WEST SUSSEX COUNTY COUNCIL CONSULTATION

TO:	Arun District Council FAO: S Davis
FROM:	WSCC - Highways Authority
DATE:	13 November 2019
LOCATION:	9-11 Abbeyfield Richmond Avenue Bognor Regis PO21 2YE
SUBJECT:	BR/145/19/PL Conversion of existing vacant residential care home into 8no. flats. Contractors site plan attached.
DATE OF SITE VISIT:	n/a
RECOMMENDATION:	Advice/ More info
S106 CONTRIBUTION TOTAL:	N/S

Construction Management Plan (CMP)

CONTRACTORS
SITE PLAN

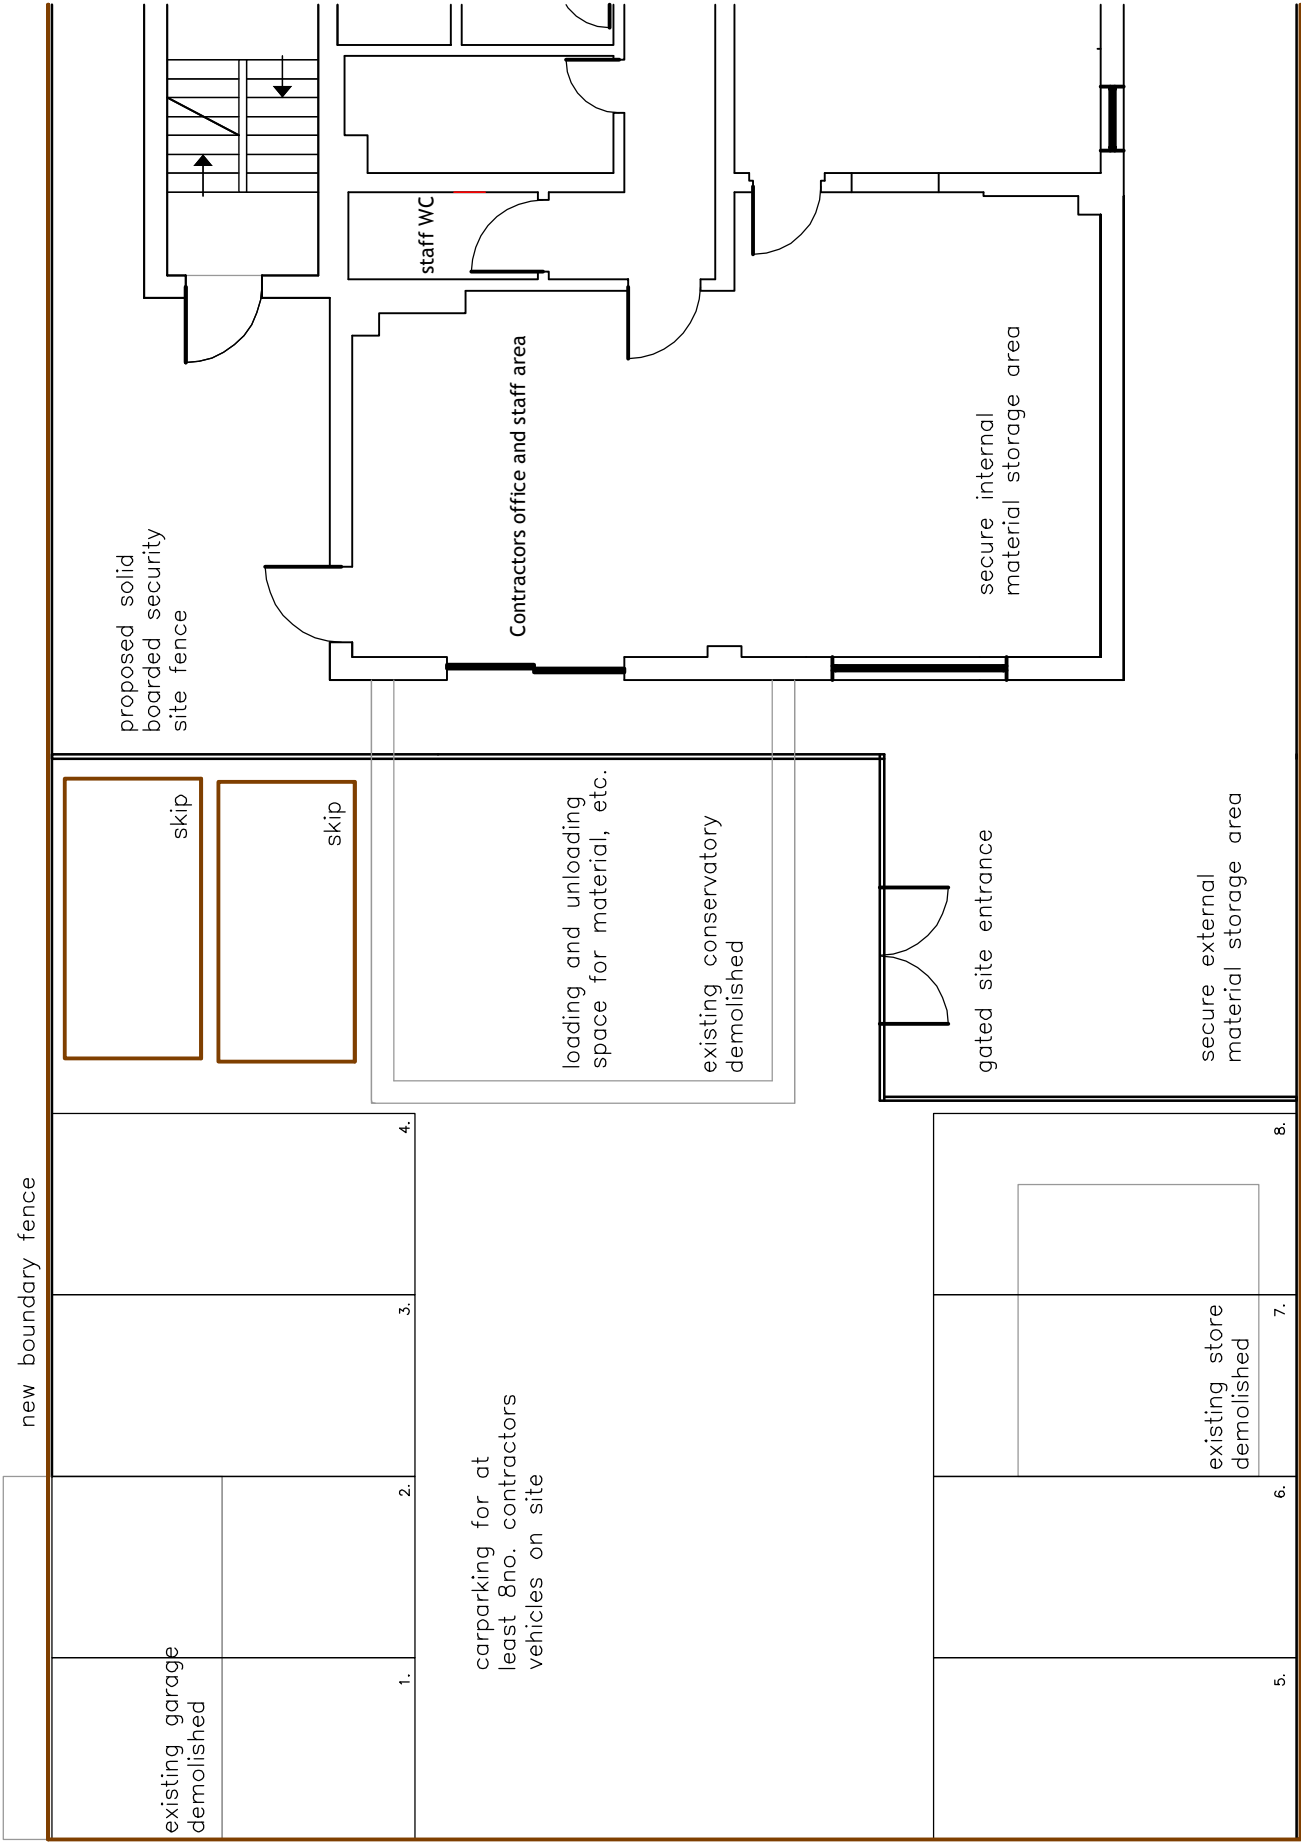
The plan submitted shows where contractors' parking will be accommodated throughout the duration of the works and where deliveries will be serviced. The LHA notes that the access route is narrow and this does seek to restrict the size of vehicles that can use this access route. Due to the nature of the works as mainly internal alterations- besides the removal of the conservatory, it is anticipated that small to medium vehicles would be sufficient for the deliveries.

However it is required that the applicant confirm the size of the vehicles that will be used and required to enter the site through the narrow access route. It would be useful to know the frequency of these movements and over what time period, to assess the impact on the highway at this point. It would be beneficial to see that the largest size vehicle is able to access and egress the site safely, a swept path diagram may be required to show this. Has the applicant considered the use of a banksman to assist with the deliveries?

The applicant should outline how deliveries will be managed given that should more than one delivery arise at a time, congestion and stacking may occur at the site access.

The access route is privately maintained however the LHA wish to ensure vehicles are not forced to reverse from the private access route onto the publicly maintained highway at Nyewood Lane, a "C" classified road to the east of

Please re consult once the above information has been provided.
